FLYING HORSE NORTH PHASE 2 PUD
PRI #2, LLC.
 EL PASO COUNTY, CO

GRADING PLANS
LEGEND & NOTES

FLYING HORSE NORTH PHASE 2 PUD / PRELIMINARY PLAN

GRADING PLANS
 LEGEND & NOTES

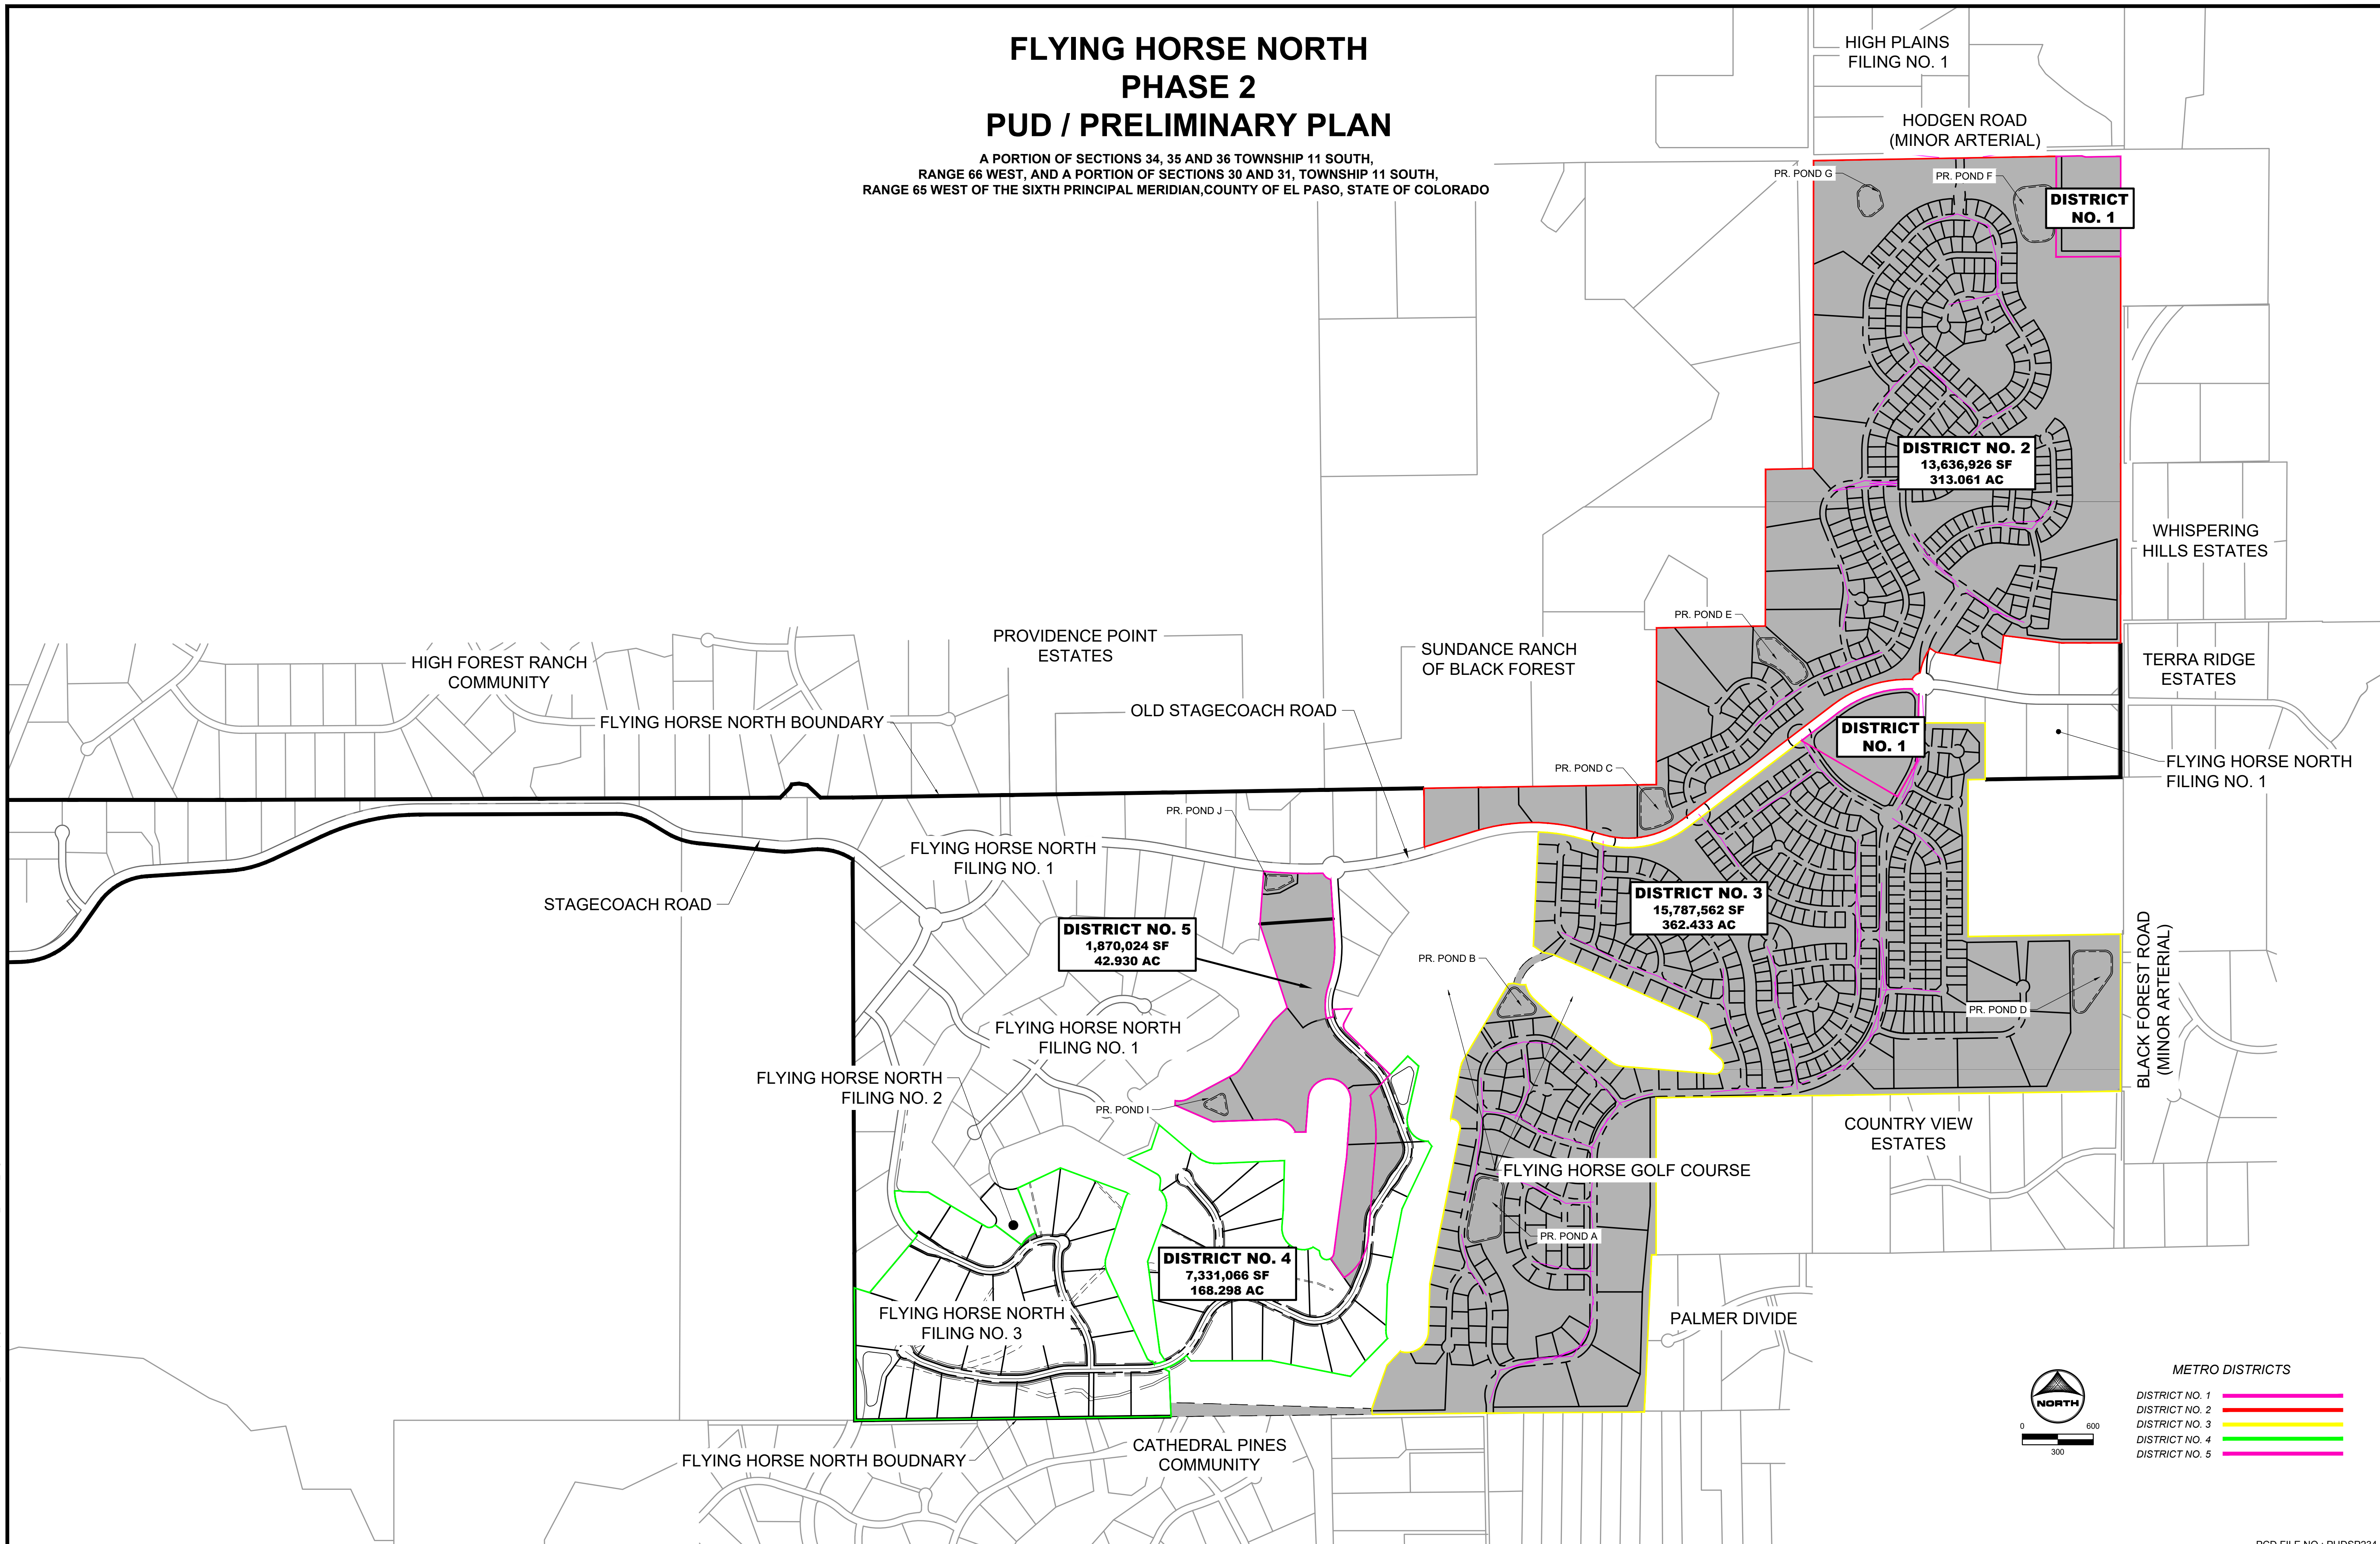
Show the proposed
improvements/developm
ent here. The Utility
plans show a pond, but
there is no label. Is that
work planned with this
development?

Show Pond I in this set
